DOUBLE SPUR RANCH
Project No. 22001

LETTER OF INTENT

RE: 52130-00-007
12420 N. Meridian Road

DOUBLE SPUR RANCH MINOR SUBDIVISION FINAL PLAT

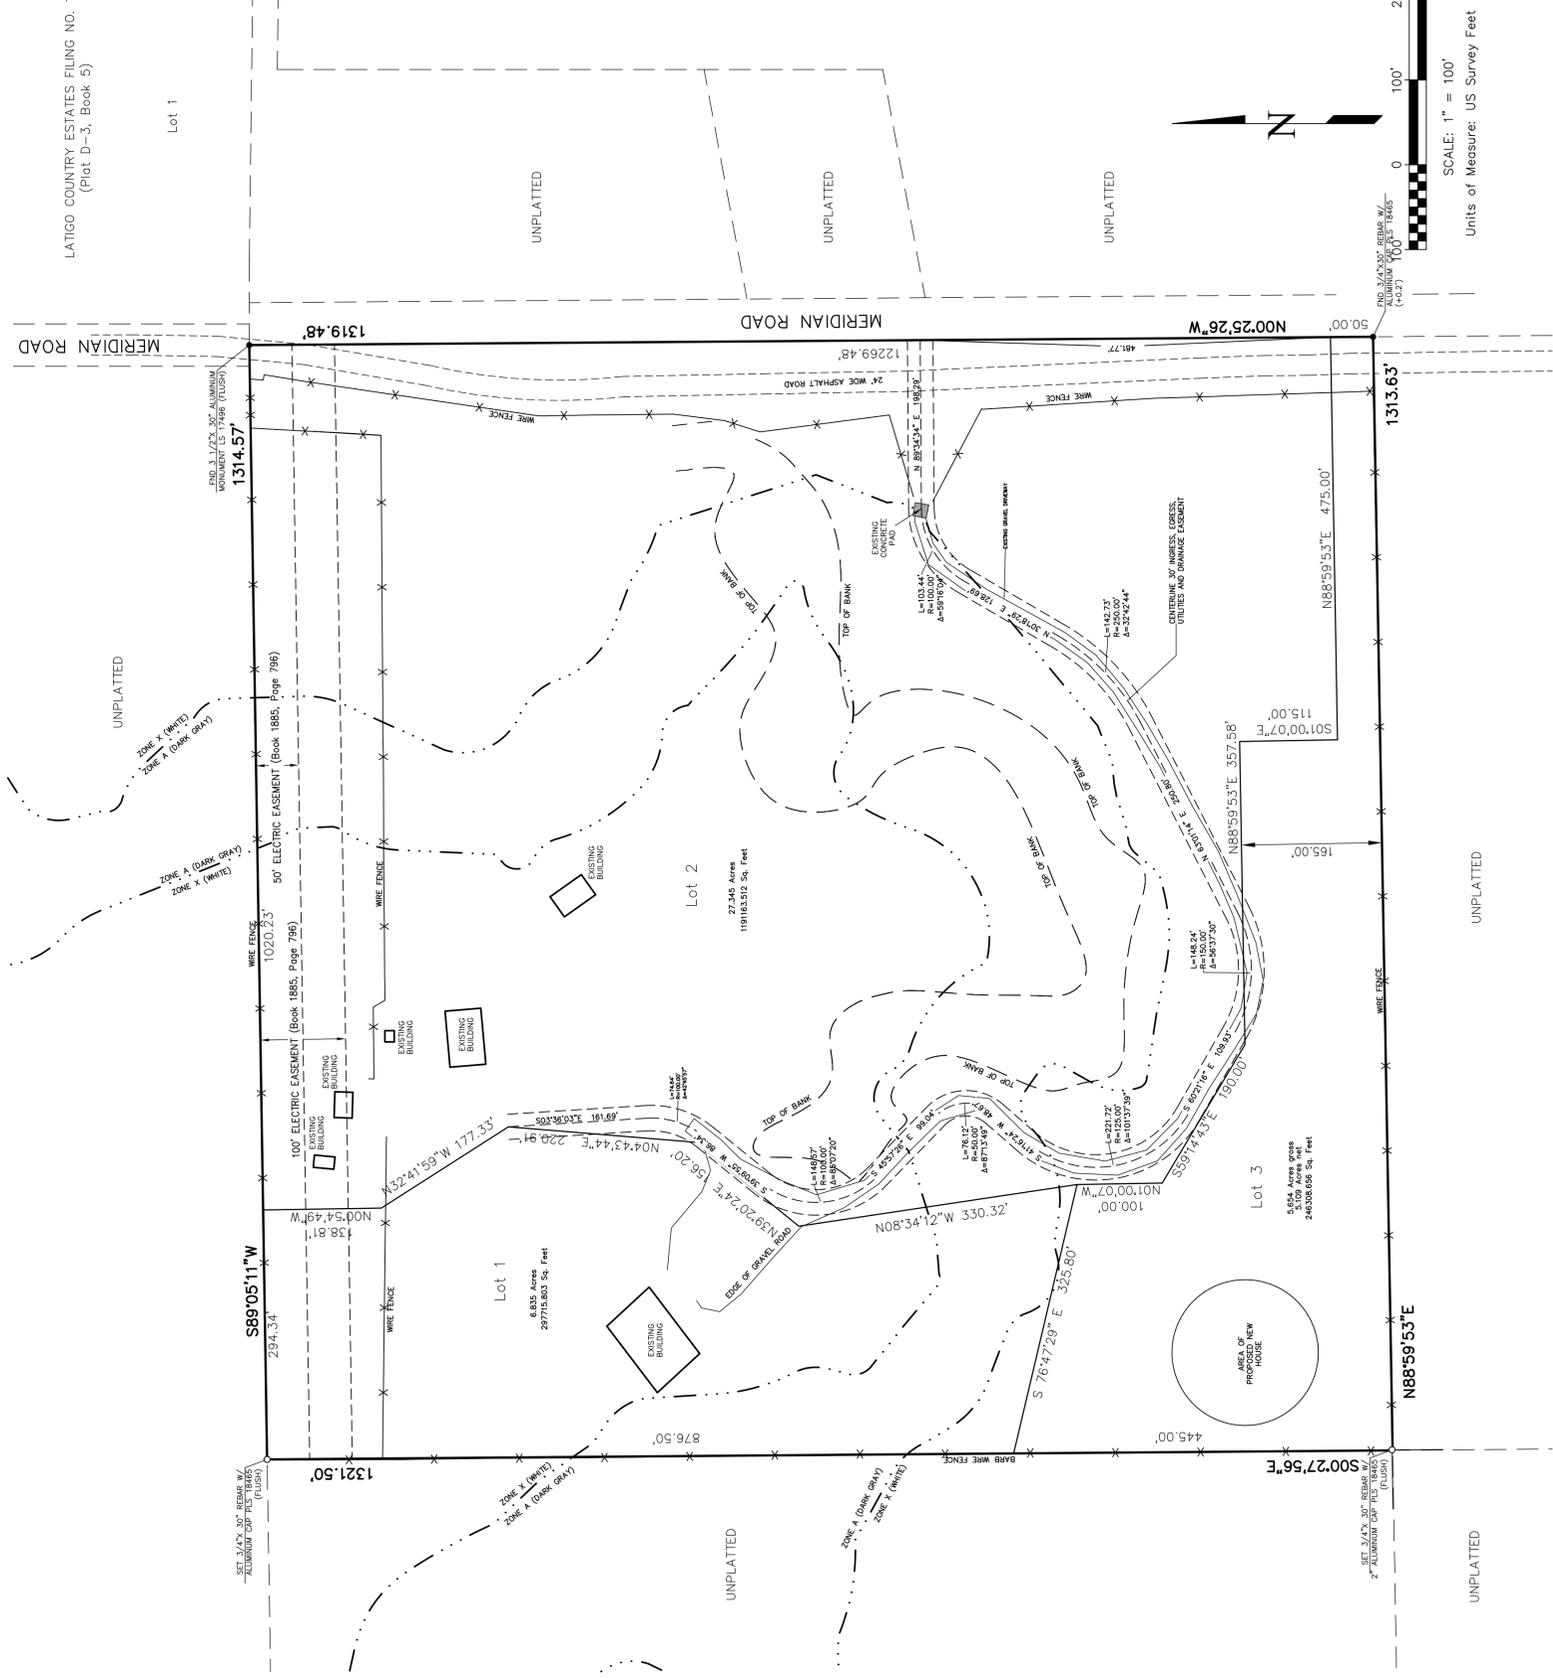
Please provide a waiver for
the base floodplain
elevations

Private driveway or road?
please clarify and clarify
on the plat
